Architects & Urban Designers
Studio 201
8 Clarke Street
Crows Nest NSW 2065

Council Reference: 342/2010
GMU Reference: Rhodes, Part 3A
Contact: Narelle Butler
Telephone: 9911-6440
Fax: 9911-6550

Application No.: 342/2010
Property: LOTS 101 AND 102, and part of 107 in DP 1134195
52 Walker Street, Rhodes NSW

Proposal: Development of four new apartment buildings with basement car parking.

**Figure 7a: Recommended *Minimum* Tree Planting Layout for the Ground Level**

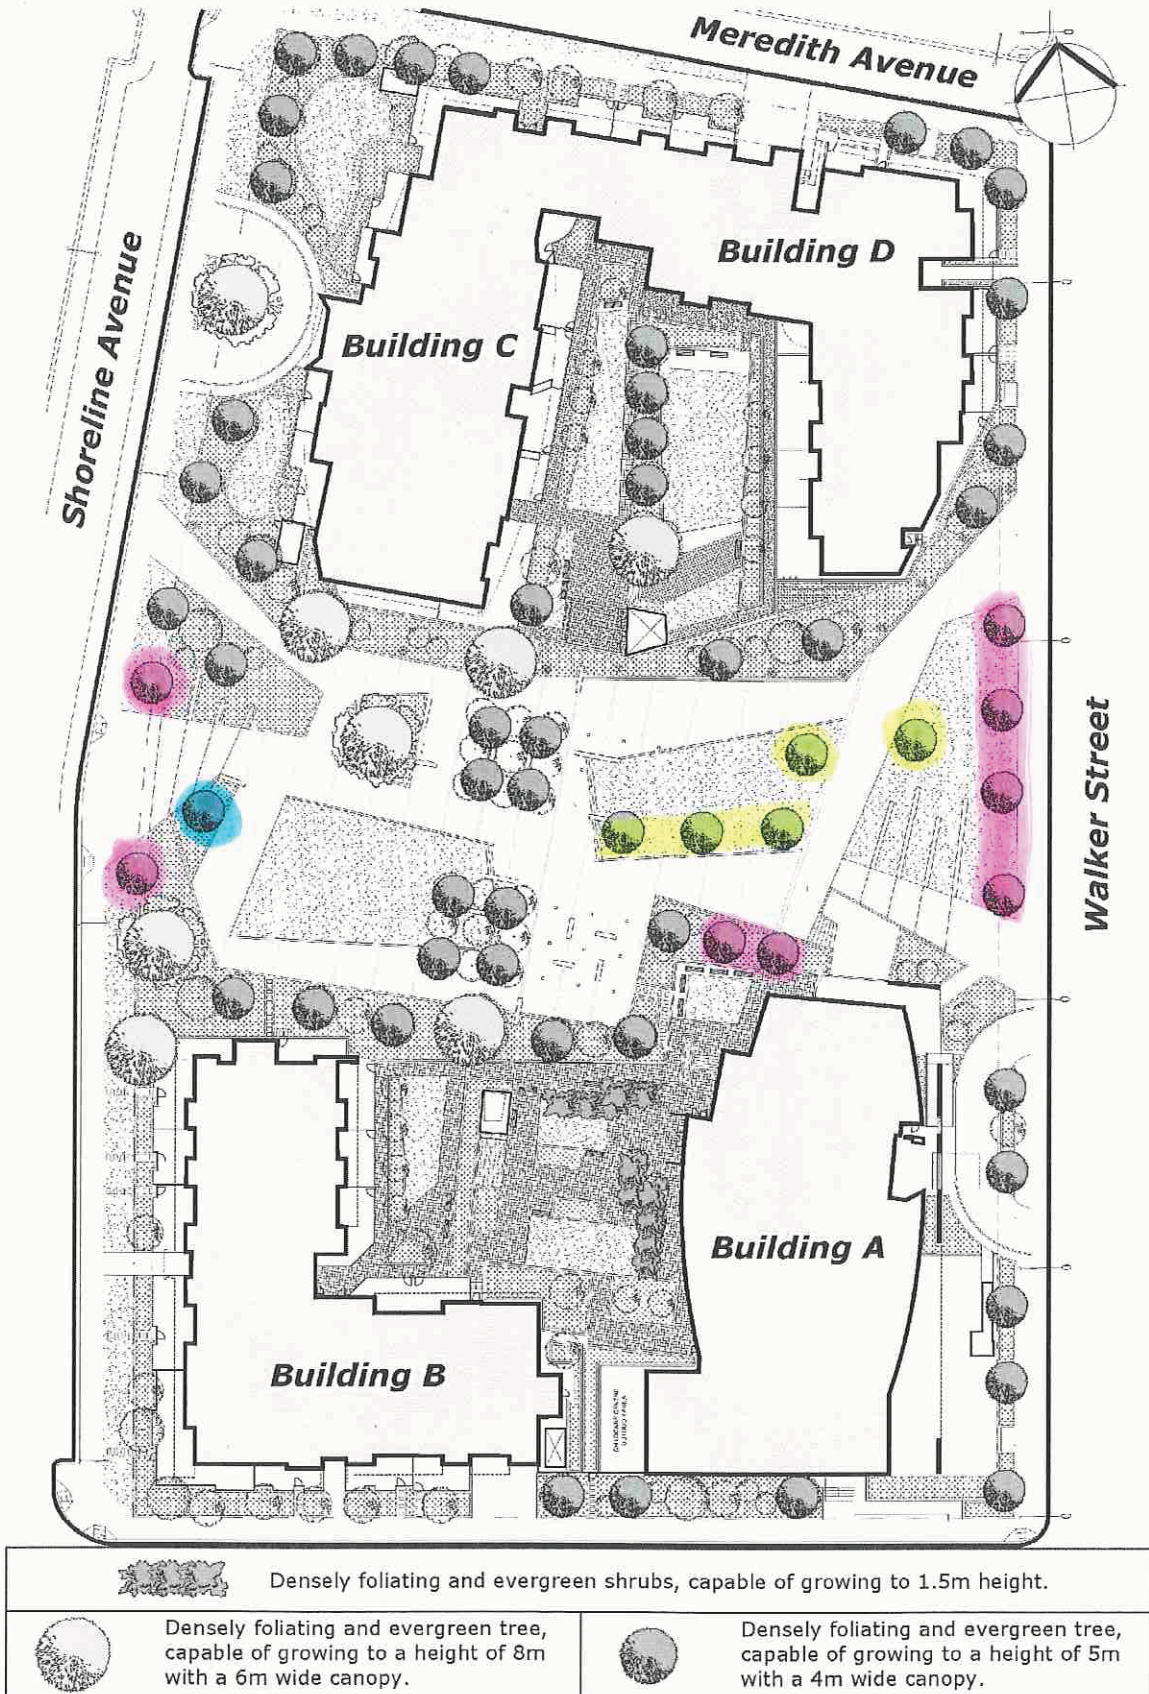
The proposal meets the numerical deep soil provision as per the Draft DCP and far exceeds that of the Residential Flat Design Code. However, the Pedestrian Wind Environment Study, Appendix 12 suggests that a number of trees (density foliated and evergreen 5m and 8m high trees with 4m and - 6m wide canopies) are required for wind mitigation (see Figure 7a: Recommended Minimum Tree Planting Layout for Ground Level pg.35).

None of the DA or Landscape Plans show a provision of deep soil, planters or boxes to accommodate these trees beyond the deep soil area concentrated towards Shoreline Drive, which results in approximately 17 required trees and 2 shrubs as shown on the Pedestrian Wind Environment Study without a proper soil provision.

- Proposed trees on the eastern part of the open space (Walker St) as suggested in the Pedestrian Wind Environment Study – appendix 12 would provide the necessary break for adverse winds created by the location of tower buildings. Please see, Environment Assessment Report- see Figure 7a: Recommended Minimum Tree Planting Layout for Ground Level p.35.

Required trees for wind mitigation need to be addressed and coordinated within the Landscape Plans.

- GMU recommends a different approach to the distribution of the deep soil area from a concentrated area to the west to a more elongated spine running parallel to the length of the open space to ensure that a deep soil provision to support mature planting can be allocated along the entire public open space. This will require a redesign of the car parking layout.

PRELIMINARY
 LANDSCAPE PLAN
 Scale: 1:200 @ B1
 Drawing Number: 101 E

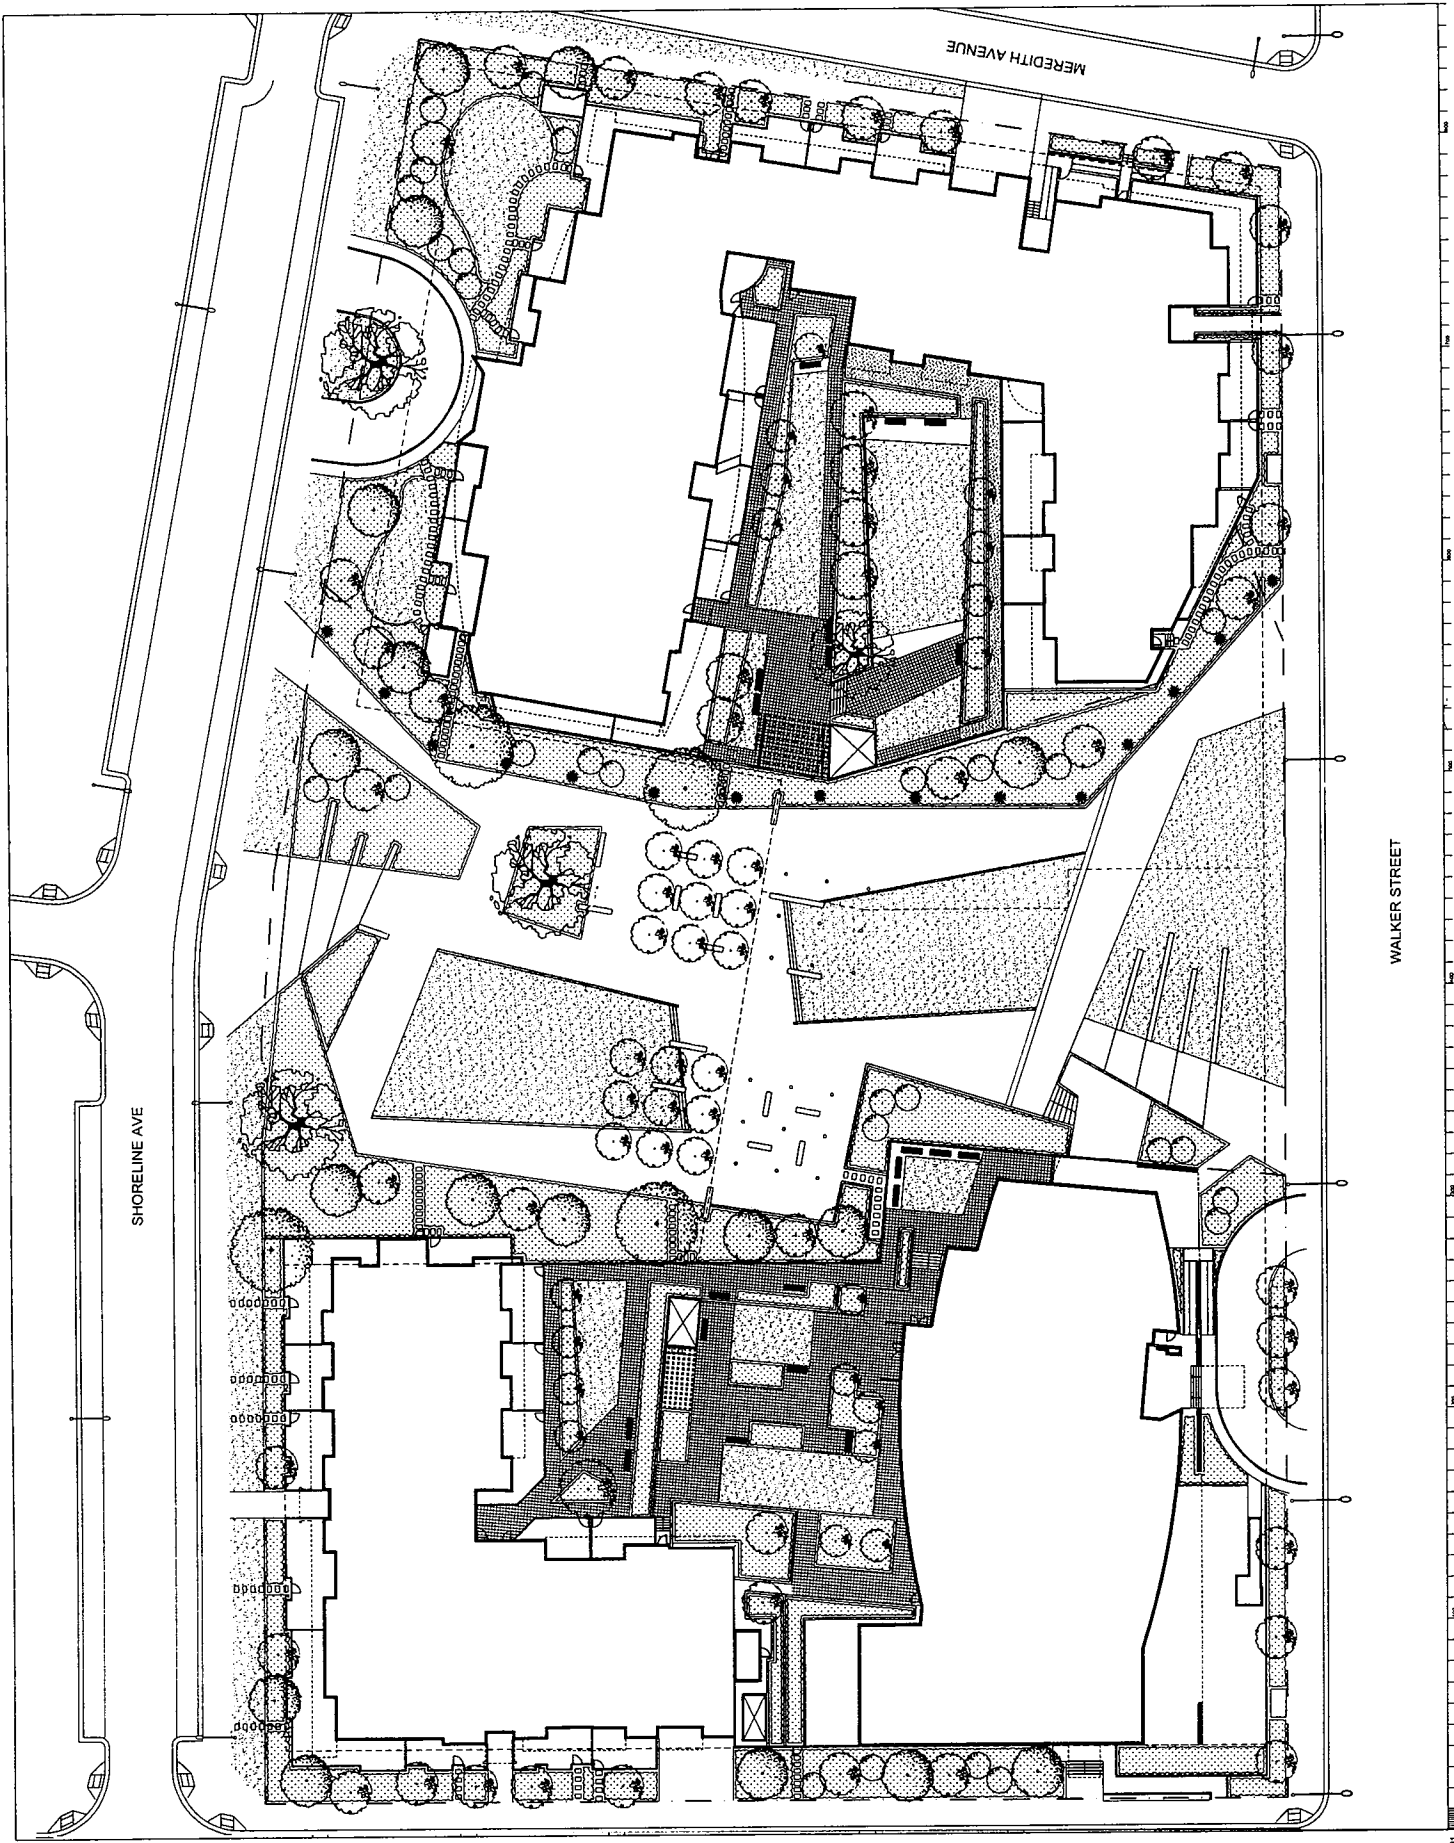
- We note John Toon's comments dated 17 of March 2010 where he suggests the creation of three separate spaces for the public open space where the area closest to Walker Street is envisioned as a hard paved area. Perhaps, this needs to be given further consideration due to the overshadowing impacts from Building C on to the public open space throughout the day as shown on the Shadow Diagrams in Appendix 27 of the EAR. The landscape plan currently shows a lack of vegetation nor the ability to accommodate the required trees for wind mitigation as discussed in the previous Deep Soil section.

- Where a deep soil provision is not possible for areas such as communal open spaces above the podium directly on top of the carparking structure, details and sections of the proposed planter boxes need to be provided. At present, drawings suggest that trees are planted directly above the concrete slab (Please see section drawings DA-67 to DA-69).
- No planting or landscape is shown as features on building elevations.
- Flat roofs above Buildings B and D will be exposed and viewed from the towers above. It is recommended that these structures be treated as green roofs populated with succulent species for amenity and good outlook for the units above.
